PLANNING AMENDMENT

Application No. H09/0498/02/A1
Date Registered 02 AUG 2002
Case Officer DM9

Description: Erection of a single storey rear annexe extension

Amendment: Revised en-suite extension
Dwg.No. 486-02-01-C

Drawing No.
01-C

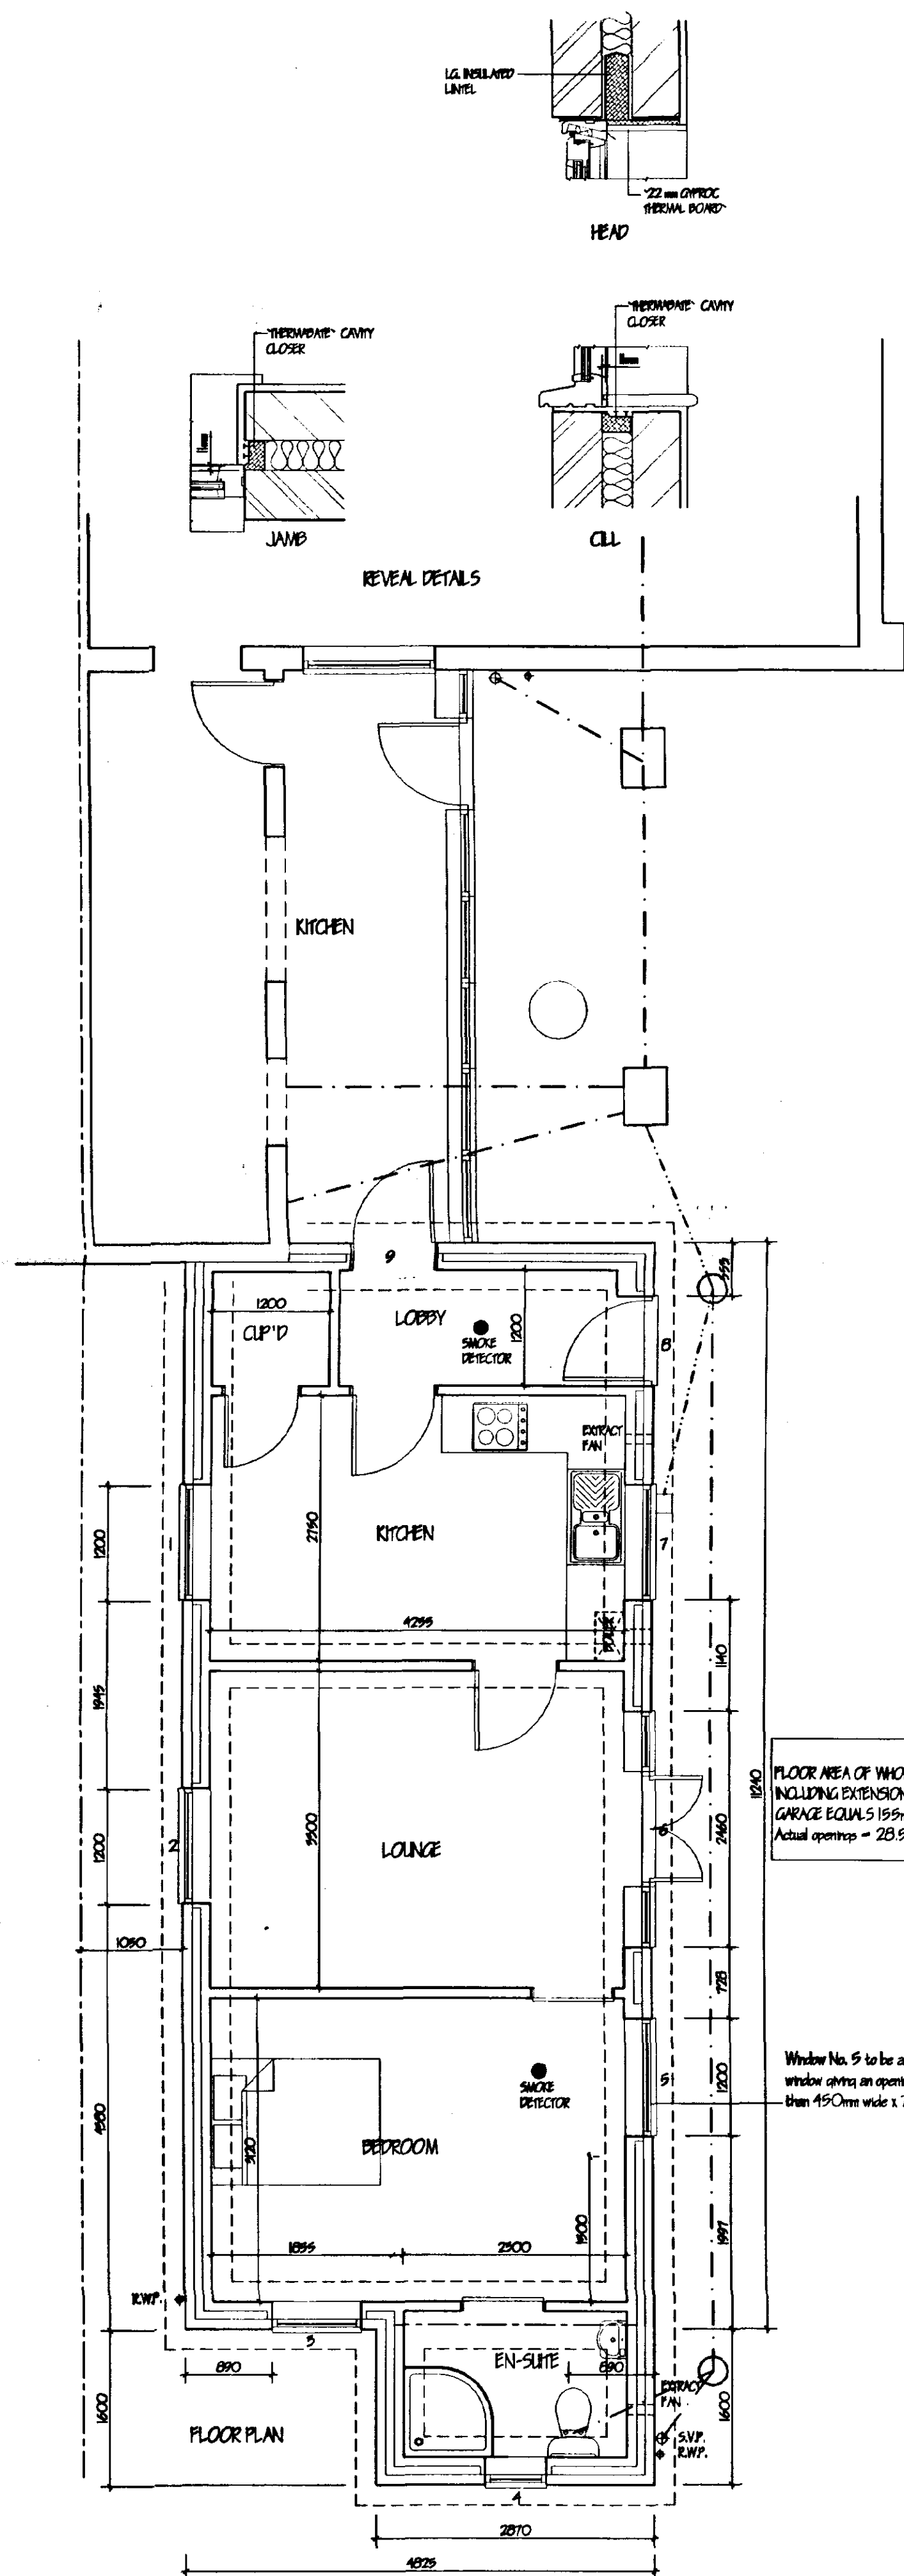
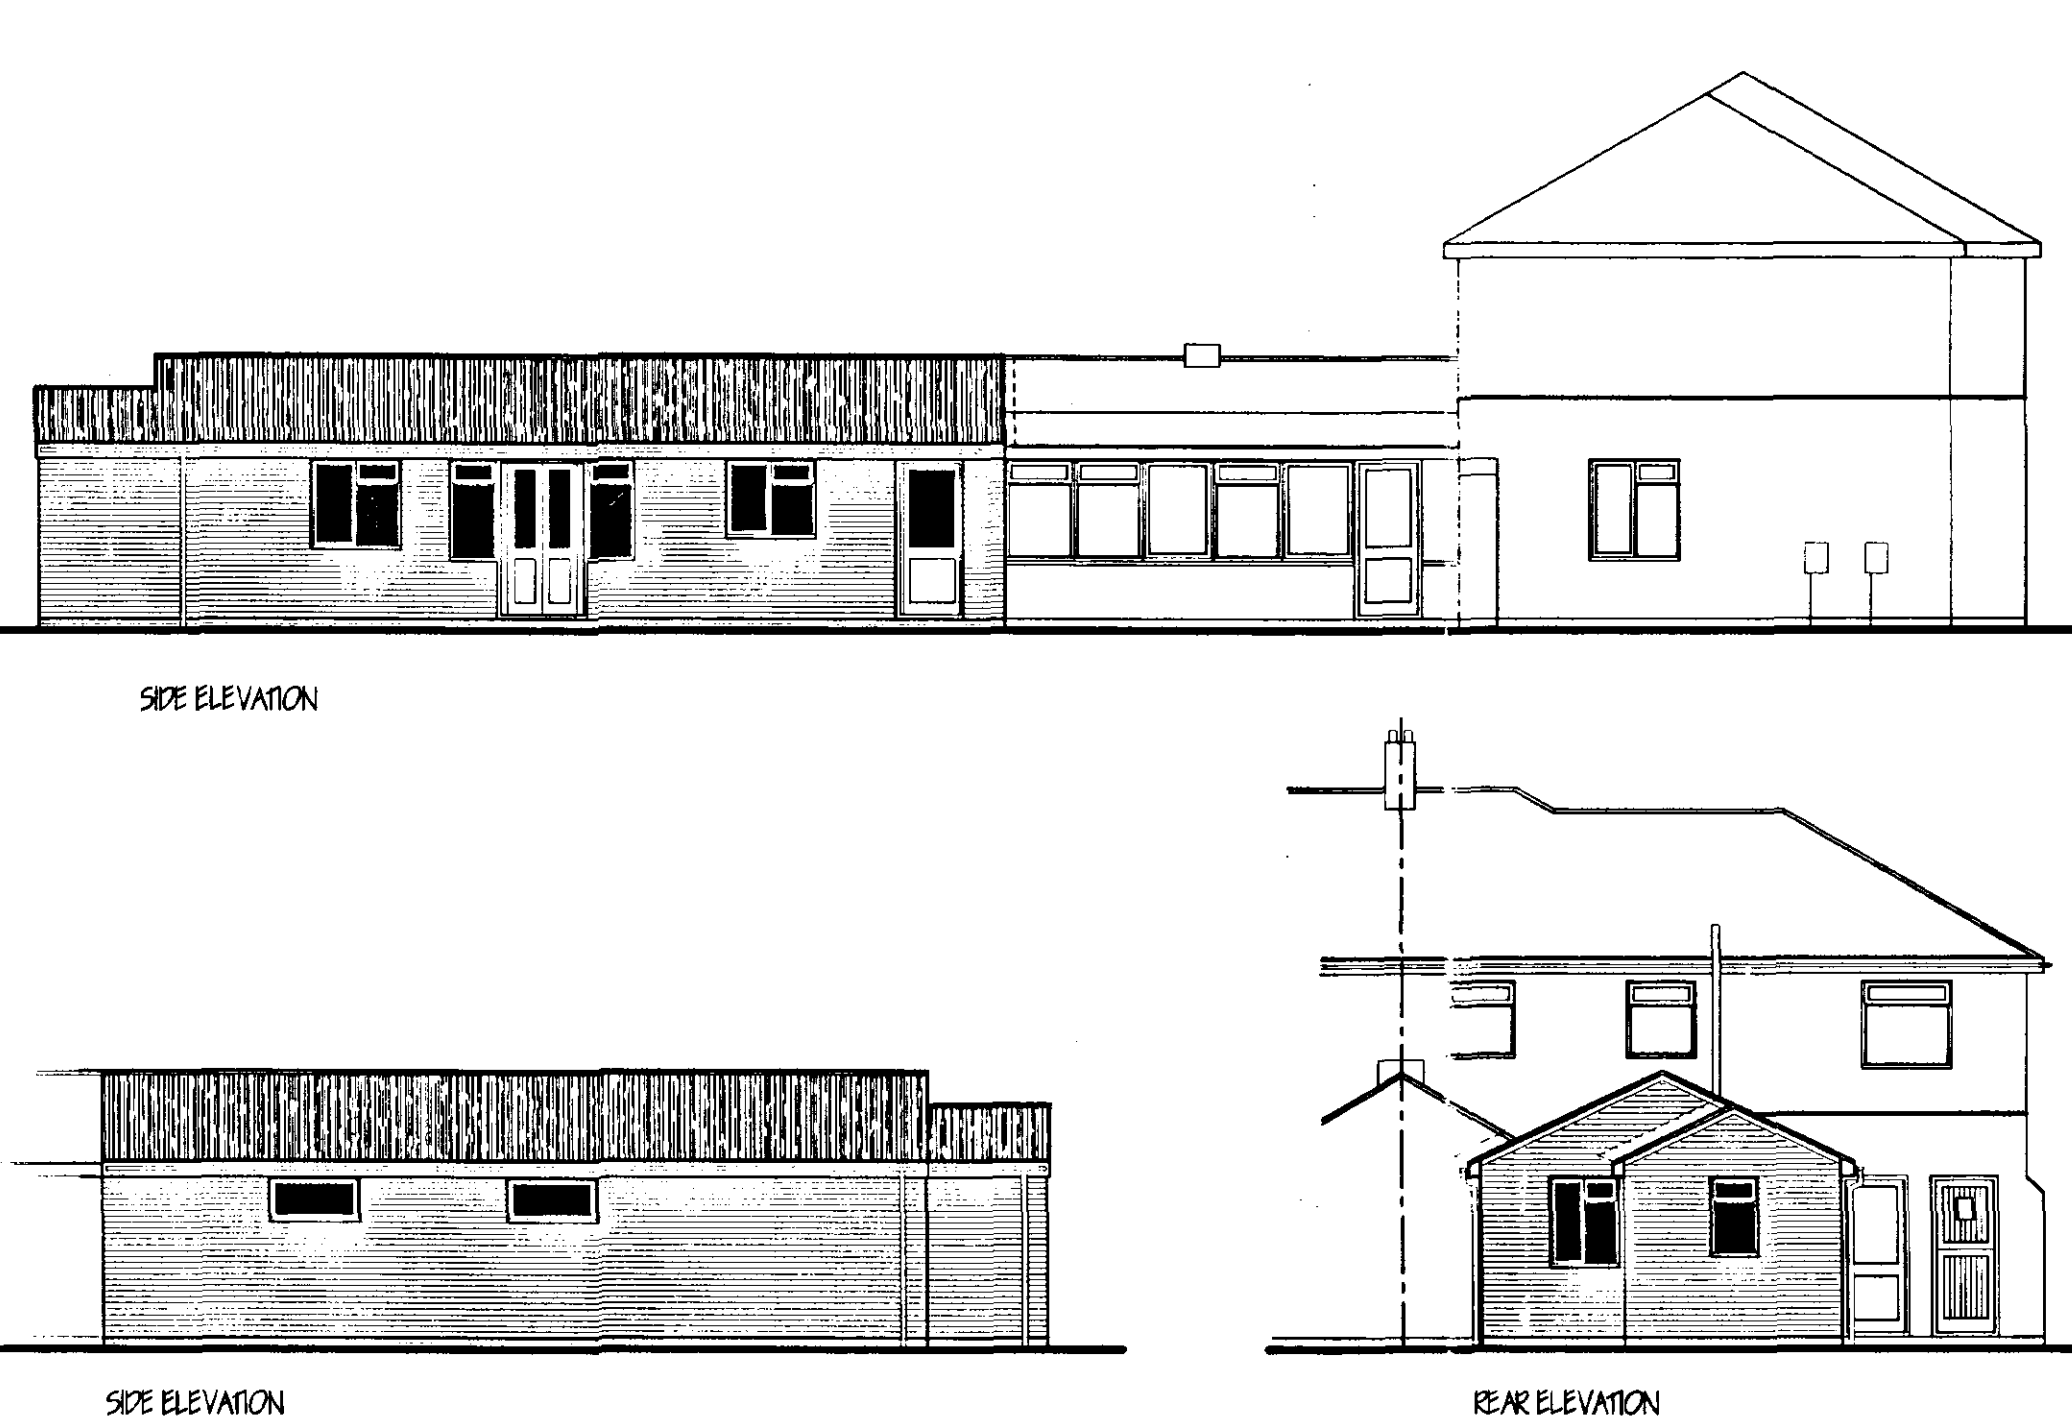
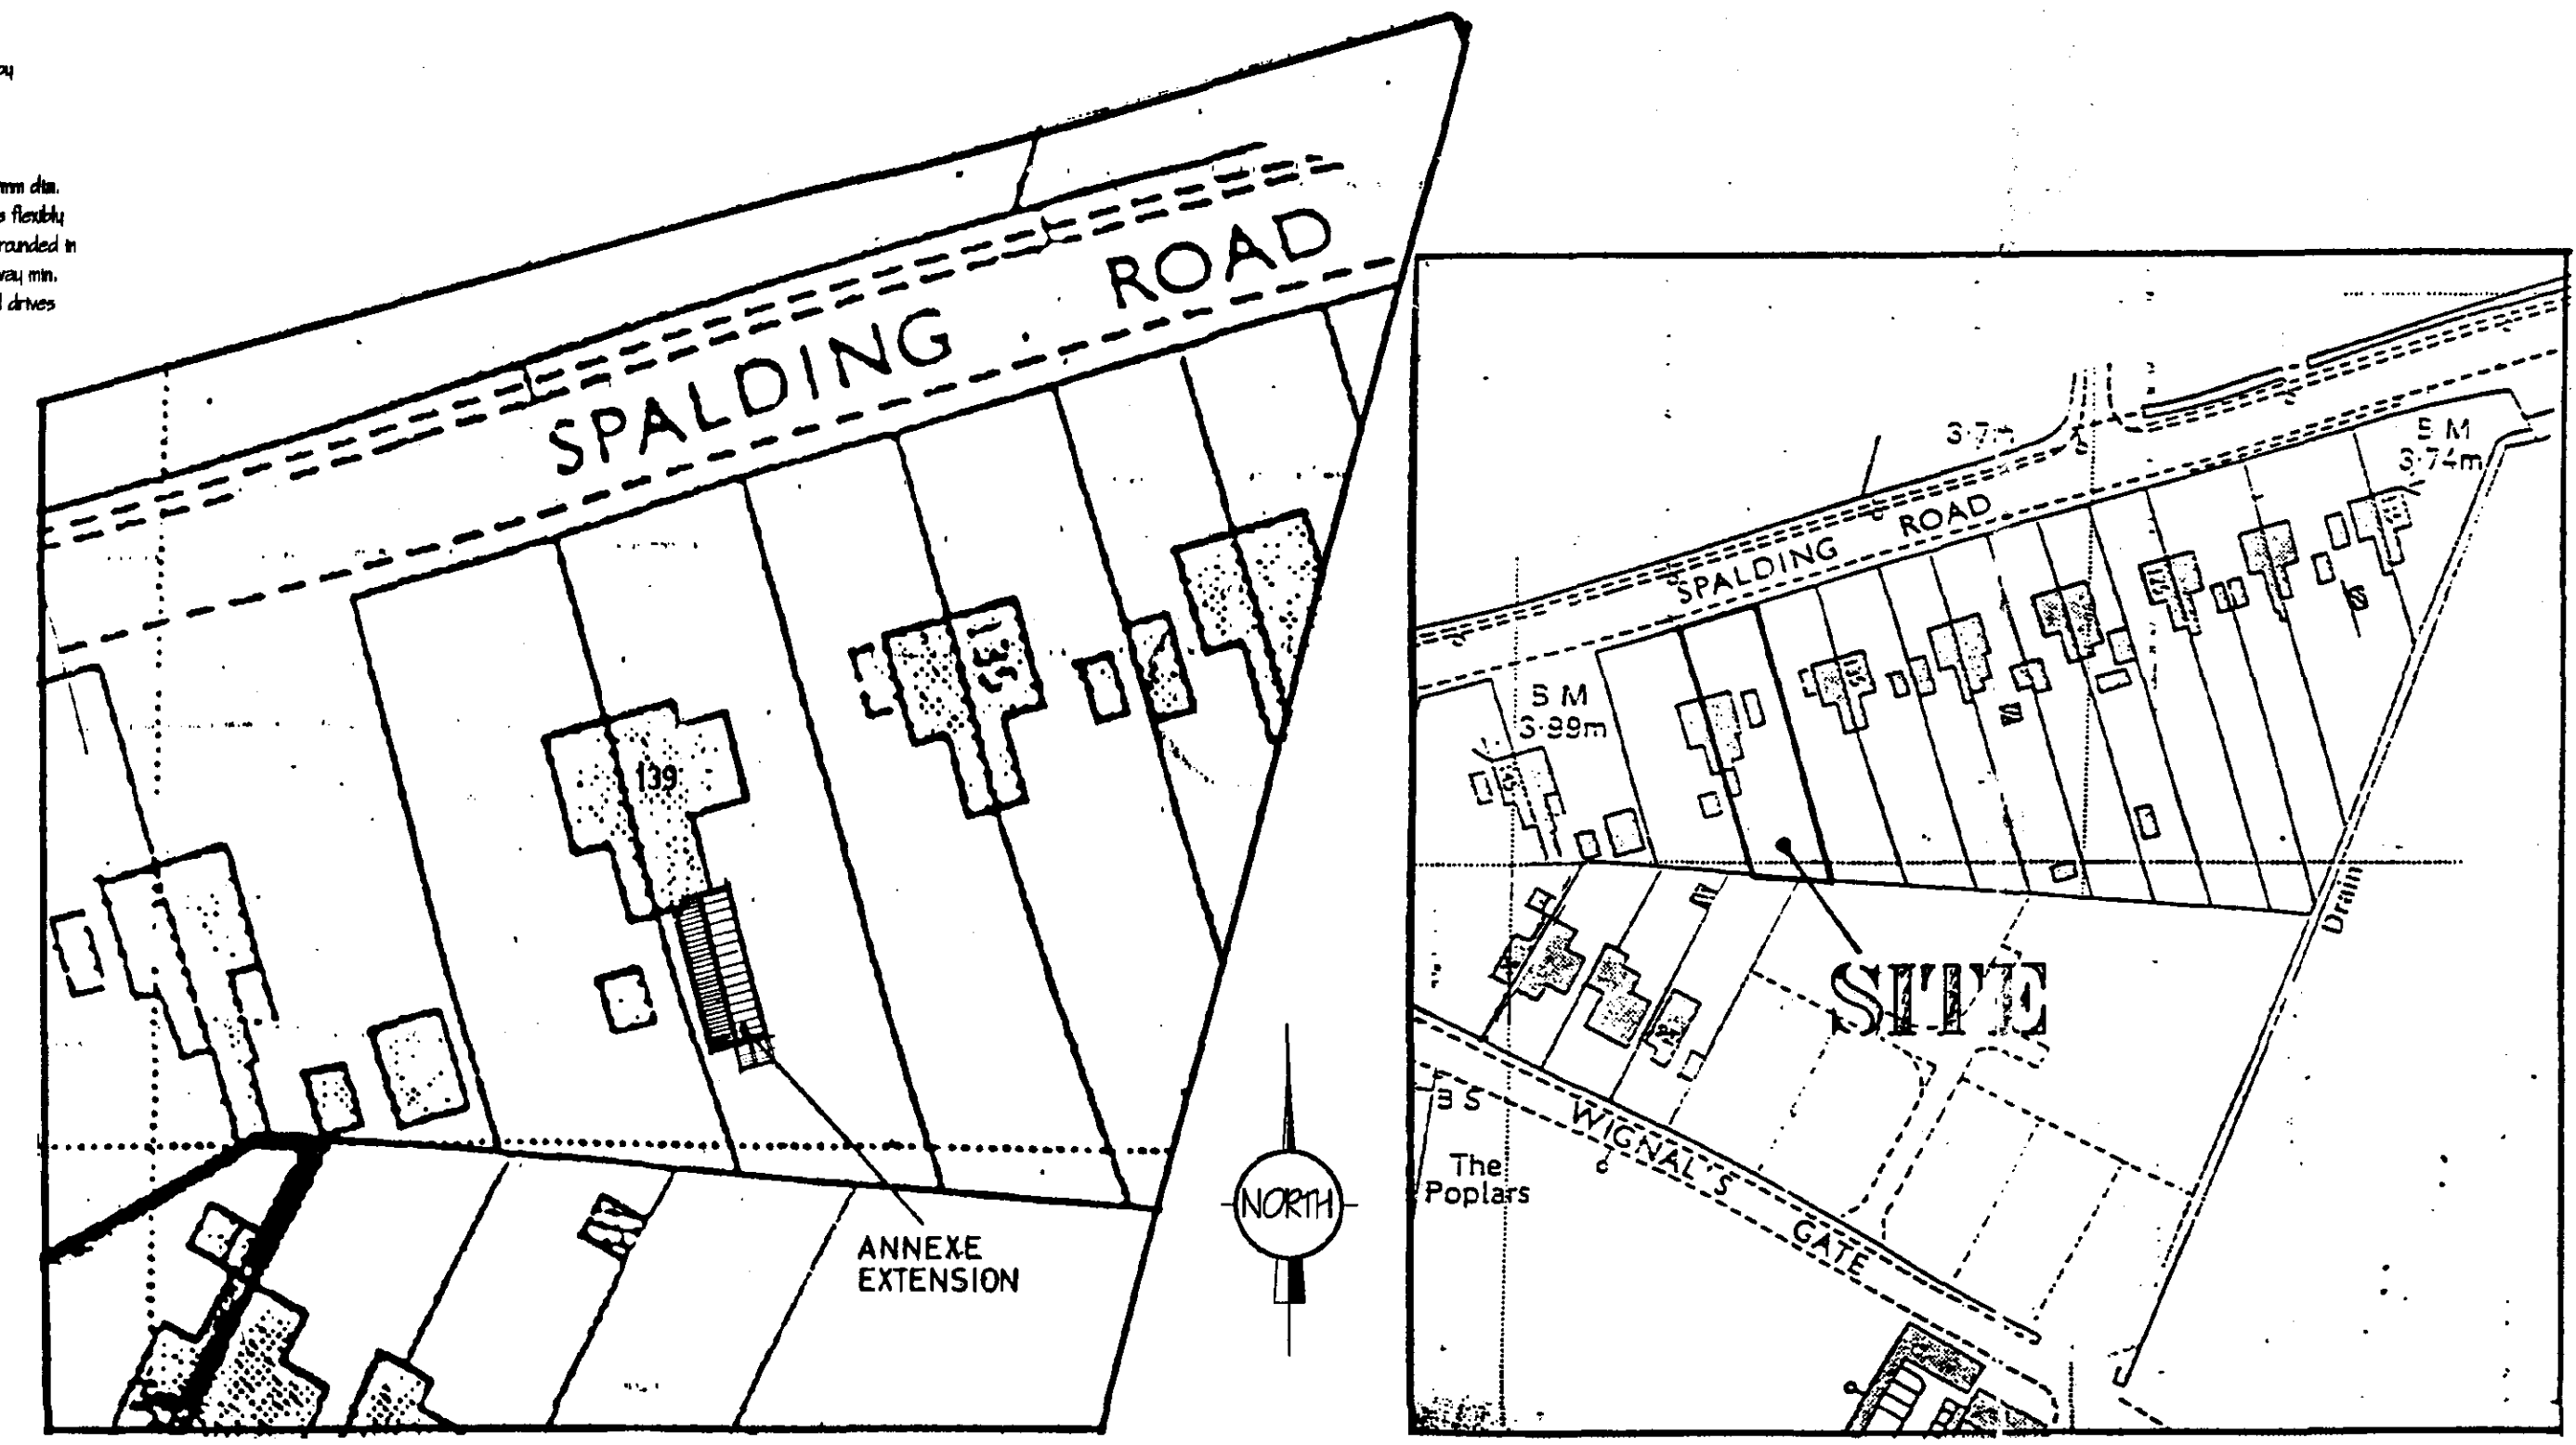
EN-SUITE EXTENSION - CLIENTS REQUIREMENTS

The amended details submitted in respect of the above proposal have now been considered and there are no objections to the amendment being implemented to the extent described above.
